DELEGATED DECISION TO DETERMINE PLANNING APPLICATIONS

Reference No:	2022/62/91467/W
Site Address:	166, Greenfield Road, Holmfirth, HD9 2LP
Description:	Erection of two storey side extension single storey front extension, conversion of existing garage and erection of link structure and alterations to existing raised lawn/seating area to rear
Recommending Officer:	Sam Jackman

Officer Report – 2022/91467

Proposed South Facing
Front Elevation
Scale 1:100

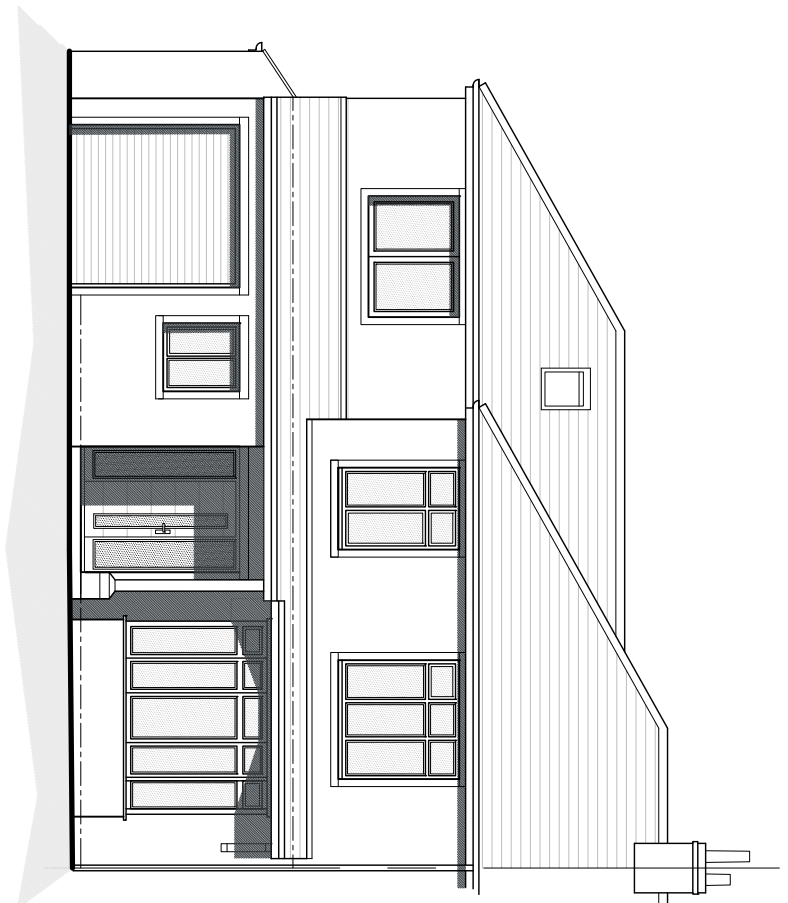
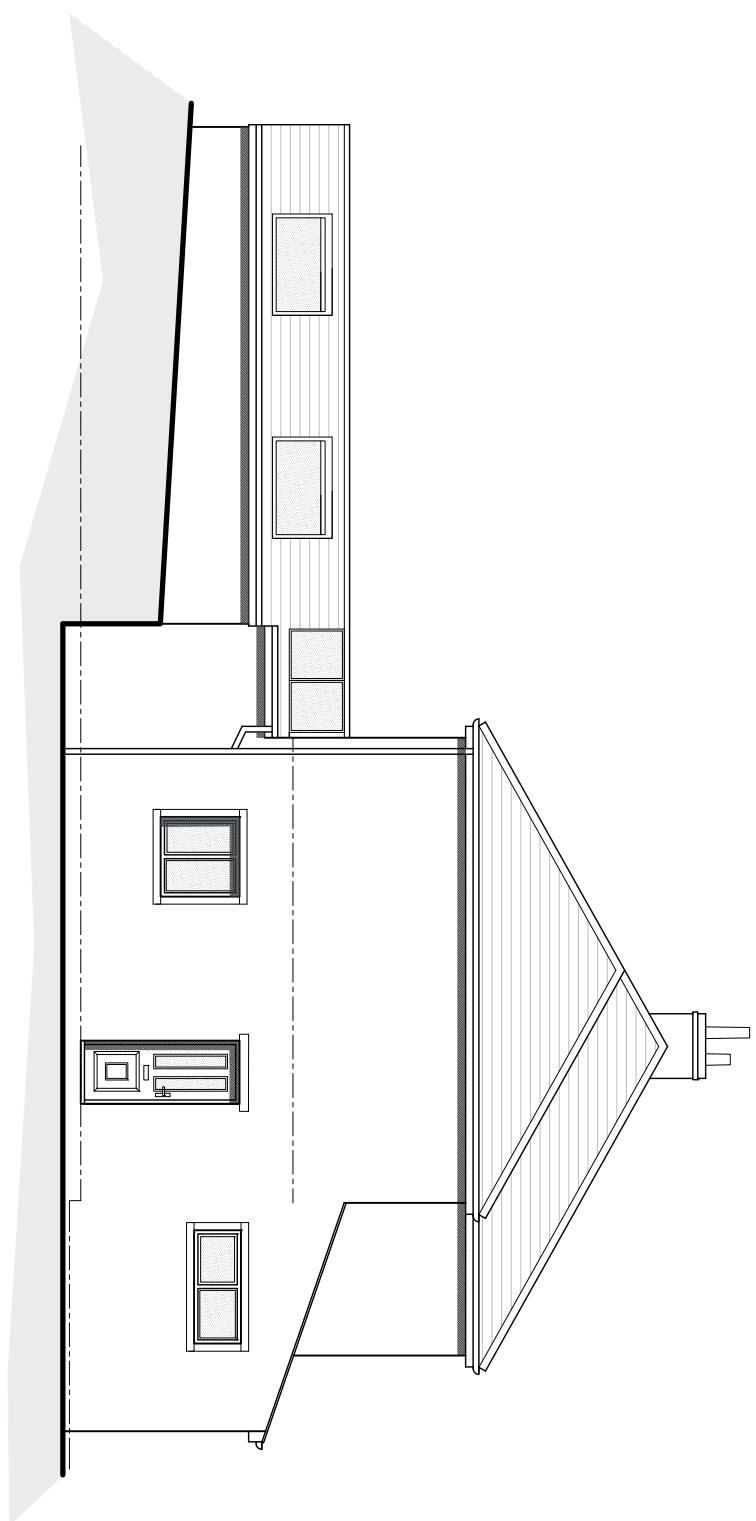
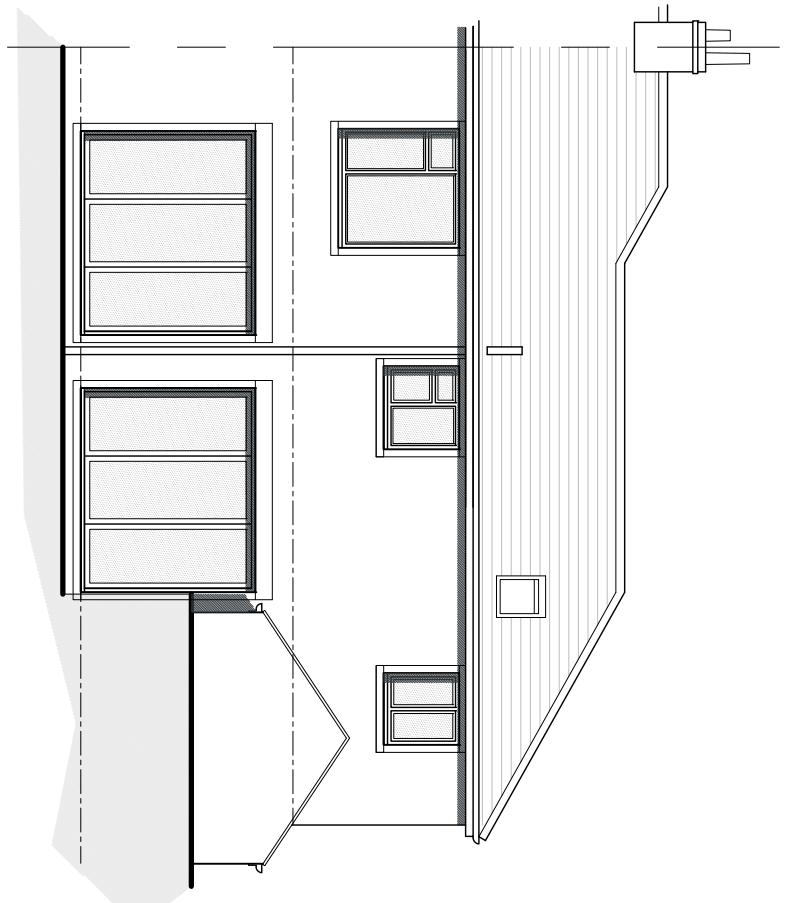
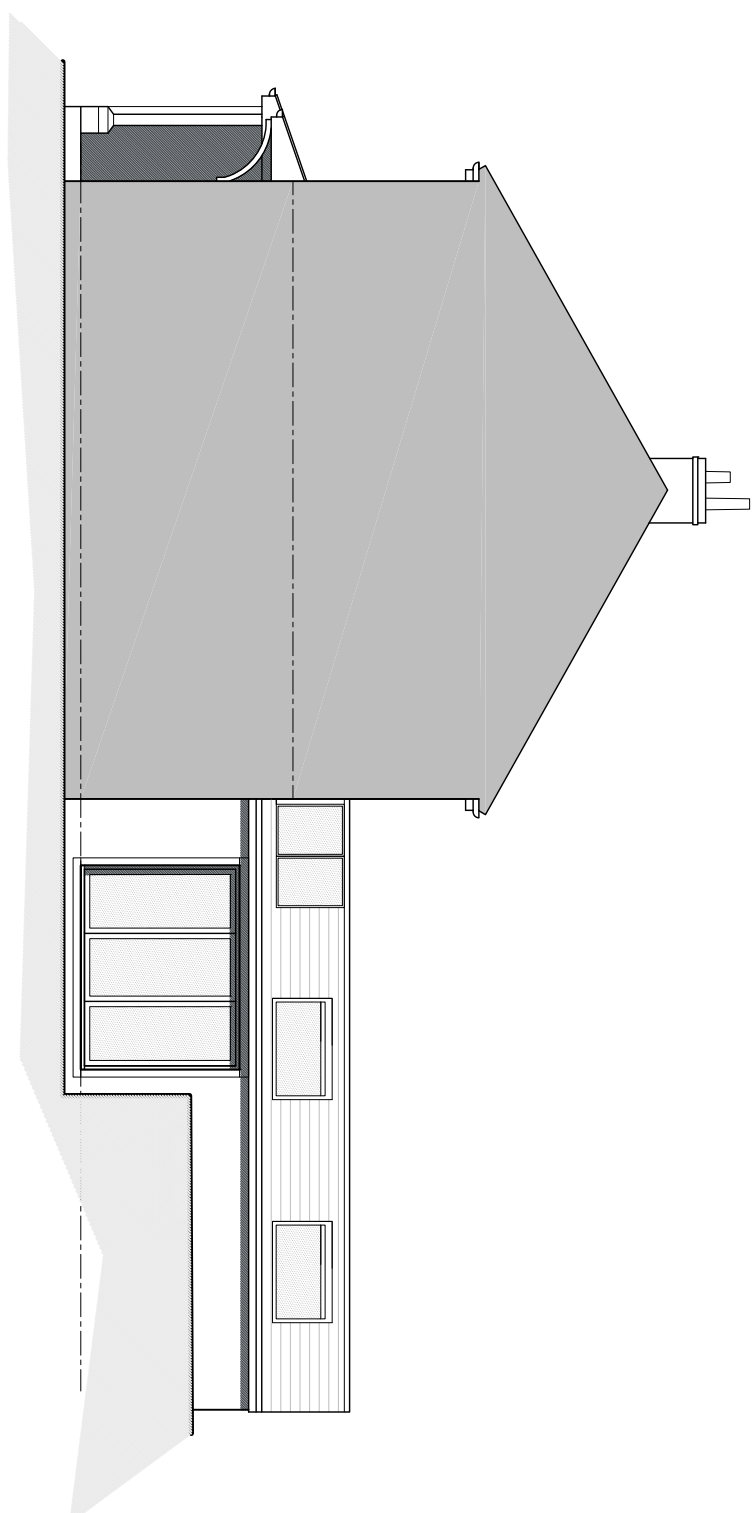
Amended plans have been received to remove the front balcony, set the single storey extension back to be in line with the bay windows and reduce the front canopy.

The proposed front extension to the front of the side extension which would project forward of the front elevation of the host property, where the lean-to roof would then extend along the front elevation over the front door and existing bay window. Where these additions would be visible from the main highway, having the potential to impact upon the appearance of the streetscape, when combined with the two-storey side extension.

However, given the property is set back approx. 14m from the road and given the greater set back of the side extension of 2m rather than the 0.5m suggested in the SPD. It is considered the combined extensions when viewed from the street would have no significant impact upon the visual amenity in this case, particularly taking account of additions to neighbouring properties in the locality being of a similar design.

Response: - Amended plans have been received reducing the size of the front extension and deleting the balcony, which simplifies the extension. Furthermore the extension is set off the boundary albeit there is no access to the rear garden, this is a preferred option but not a requirement. The design of the extension on balance is considered to be acceptable.

Proposed Ground Floor Layout
Scale 1:50

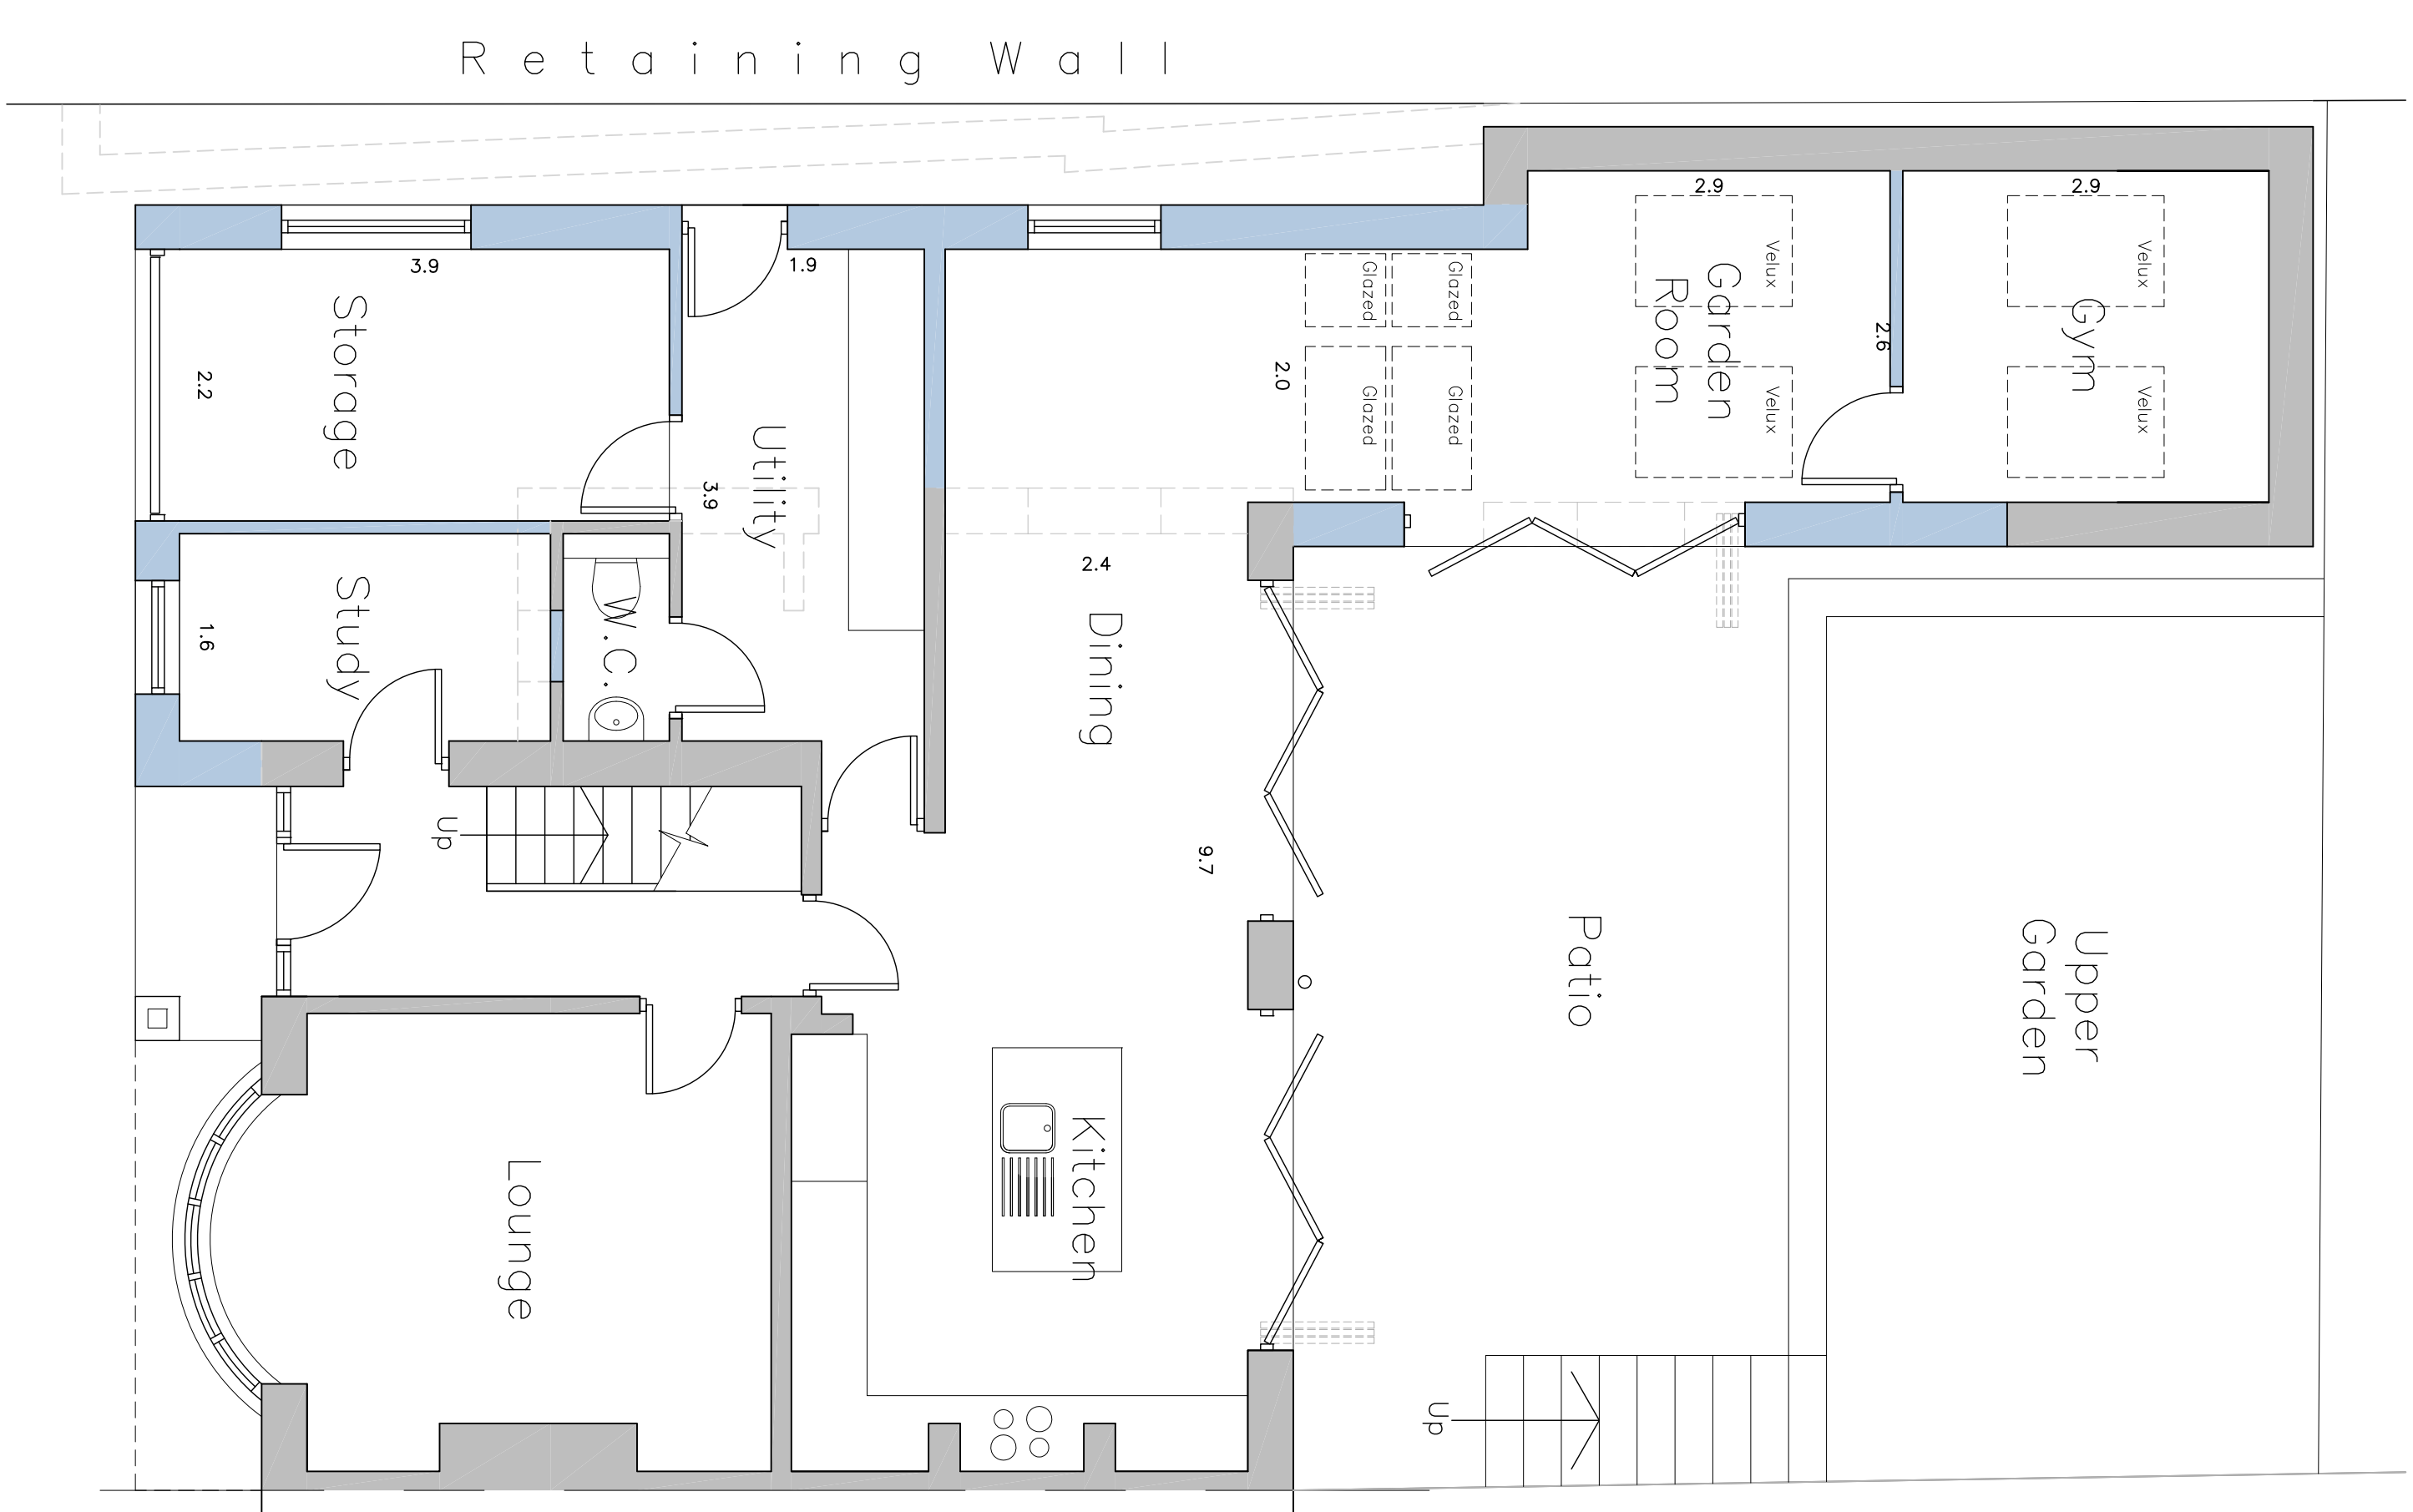
The proposed single storey rear extension in this case would project 1.5m and would be set in from the shared boundary by 7m with No. 164 which is to the east of the application site with a dual pitched.

With regards overlooking of this neighbour the proposal shows new bifold doors within the garage conversion where this window would overlook the applicant's patio and towards the neighbour's extension which projects approx. 3m, close to the boundary. Within the side elevation of the neighbour's extension there are high level windows therefore, given this relationship the bifold's wouldn't lead to any significant level of overlooking to no. 164 occurring and is considered acceptable.

With regards overlooking the proposal includes 2 ground floor side windows overlooking the shared boundary however, given the existing hedge to both properties, the difference in levels and albeit the neighbours have 2 ground floor & a first-floor bathroom window in their gable they appear to be non-habitable room windows, therefore, it is considered no significant overlooking would occur.

Proposed Site Layout
Scale 1:200

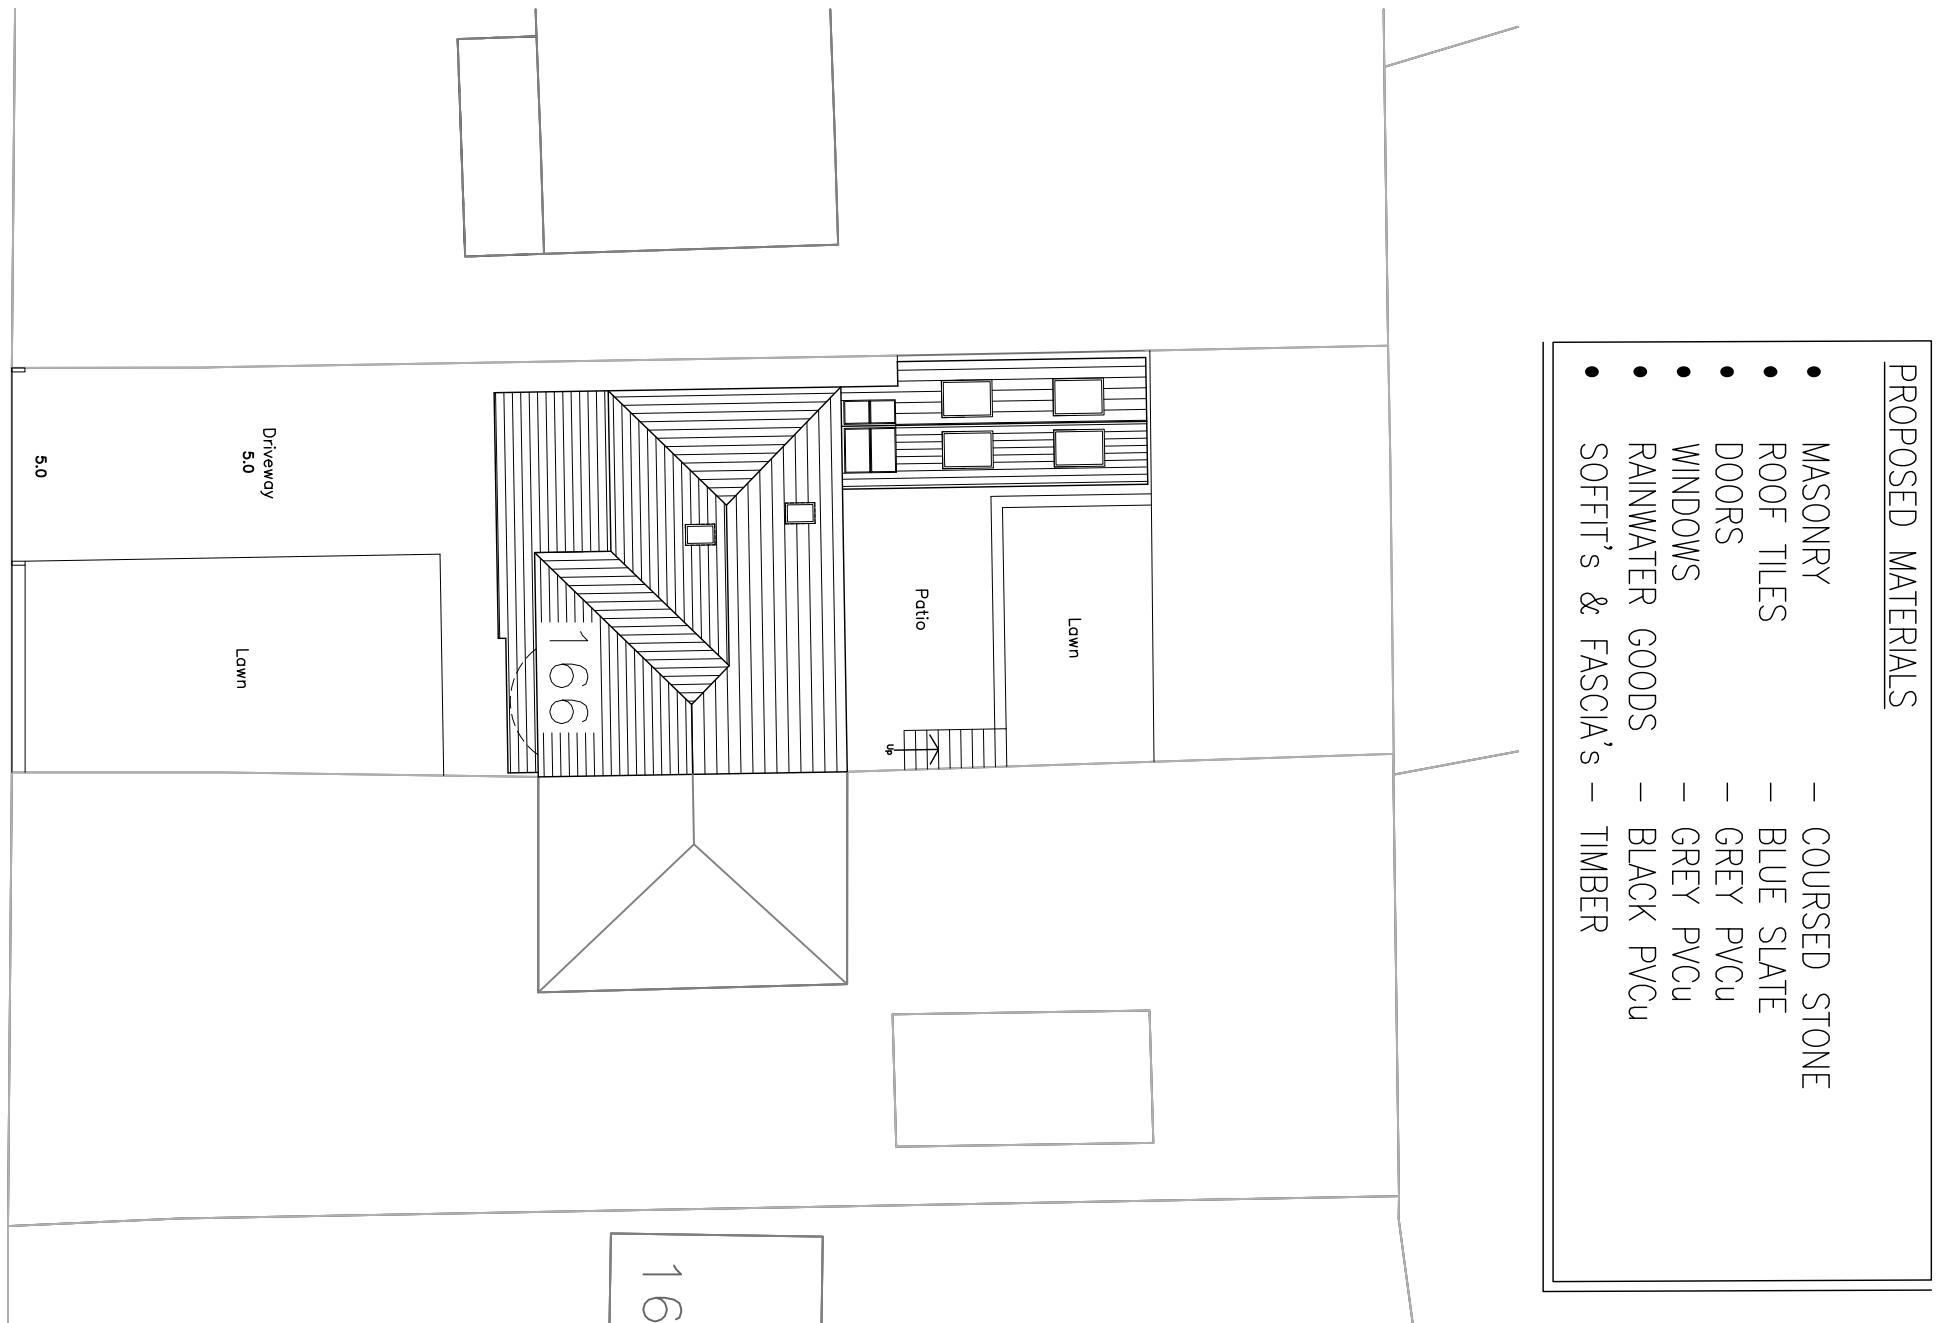
In this case the proposal would create a 4-bedroom property where albeit the garage will be lost, the access is restricted due to the existing single storey side extension and potential only used for storage. The remaining drive would remain at approx. 13.5m in length and is double in width where the property can still accommodate 3 cars as such would meet the aims of Policy LP22 of the Kirklees Local Plan with respect to highway safety and advice in Chapter 12 of the National Planning Policy Framework.
